**RMS AND TfNSW CONSULTATION MEETING MINUTES
STATE SIGNIFICANT DEVELOPMENT (SSD) 9210
PROPOSED SAINTS PETER AND PAUL CHRISTIAN PRIMARY SCHOOL
17-19 KOSOVICH PLACE, CECIL PARK (LOT 2320 & 2321 DP 1223137)**

Meeting Time and Date: 3.30pm, 13 January 2020

SSD 9210 - Saints Peter & Paul Assyrian Primary School, 17 - 19 Kosovitch Place, Cecil Park, 2178

FIGURE 3: PROPOSED INTERSECTION LAYOUT

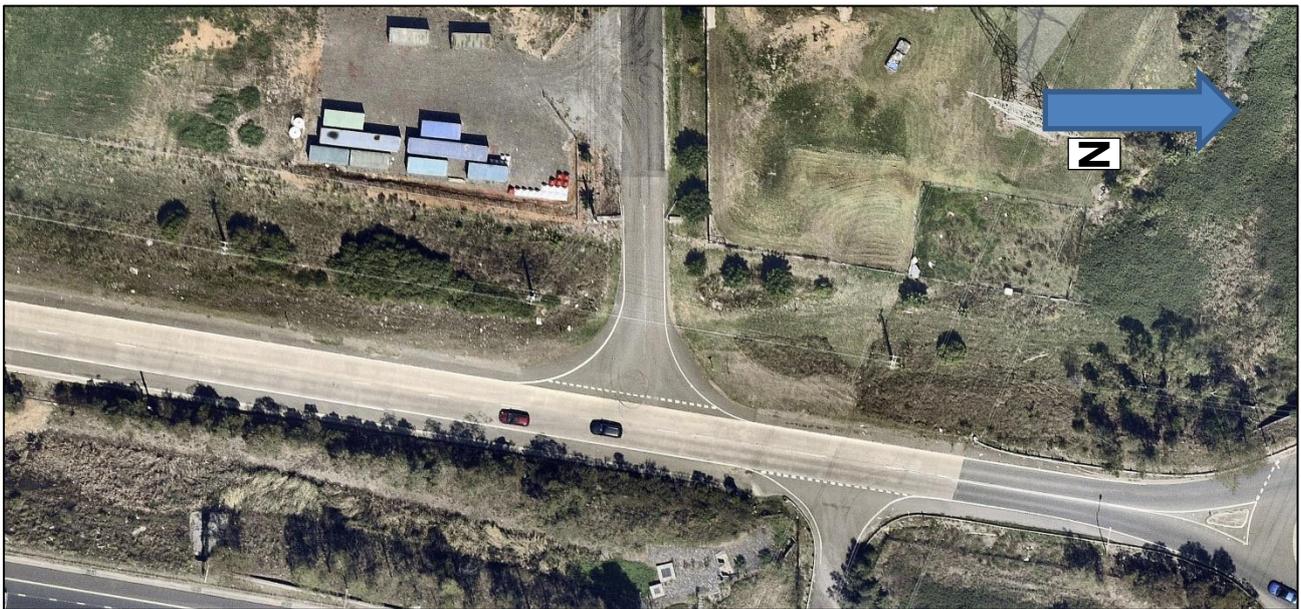
- A roundabout treatment was investigated for the intersection of Kosovitch Place and Wallgrove but was found an infeasible solution due to the physical constraints of the site;
- The only alternative feasible treatment, at this stage, is a priority controlled intersection. The design has safety concerns which need to be investigated; and
- The right turn treatment for the intersection from Wallgrove Road onto Kosovitch Place need to be investigated further by the applicant (see Figure below) and the below key elements to be addressed.

1. Kosovitch Place is observed to be utilised by HRVs by local residents and as such required to be designed with HRVs as the largest design vehicle;
2. The proposed CHR is a key safety concern particularly with extended queuing that may implicate the adjoining intersection of Villers Road and the limited capacity it provides for right turn treatment and vehicle queuing;

3. & 4. Right Turn Ban to be put in place with a traffic directing medium island located on Kosovitch Place limiting traffic movements from the approach to only Left Out. The public consultation would need to be undertaken by Council for the right turn ban from Kosovitch Place onto Wallgrove Road. A traffic Management Plan for the right turn ban from Kosovitch Place onto Wallgrove Road is required to be provided to Transport for NSW for approval before the right turn ban can be reported to the Local Traffic Committee. Kosovitch Place is a local Road and therefore, the applicant need to discuss this with Council regarding the right turn ban.

5. Left turn deceleration is required to be design with accordance to the standards for the west bound traffic.

The application is to be modified showing the abovementioned key elements are addressed (through an amended TIA and supporting SIDRA modelling) and submitted to TfNSW for review prior to the determination of the application. Concept Civil design plans and supporting swept path plans are required for TfNSW to make an assessment of the application. Upon receipt of the abovementioned information, TfNSW will undertake an assessment and provide a response accordingly.
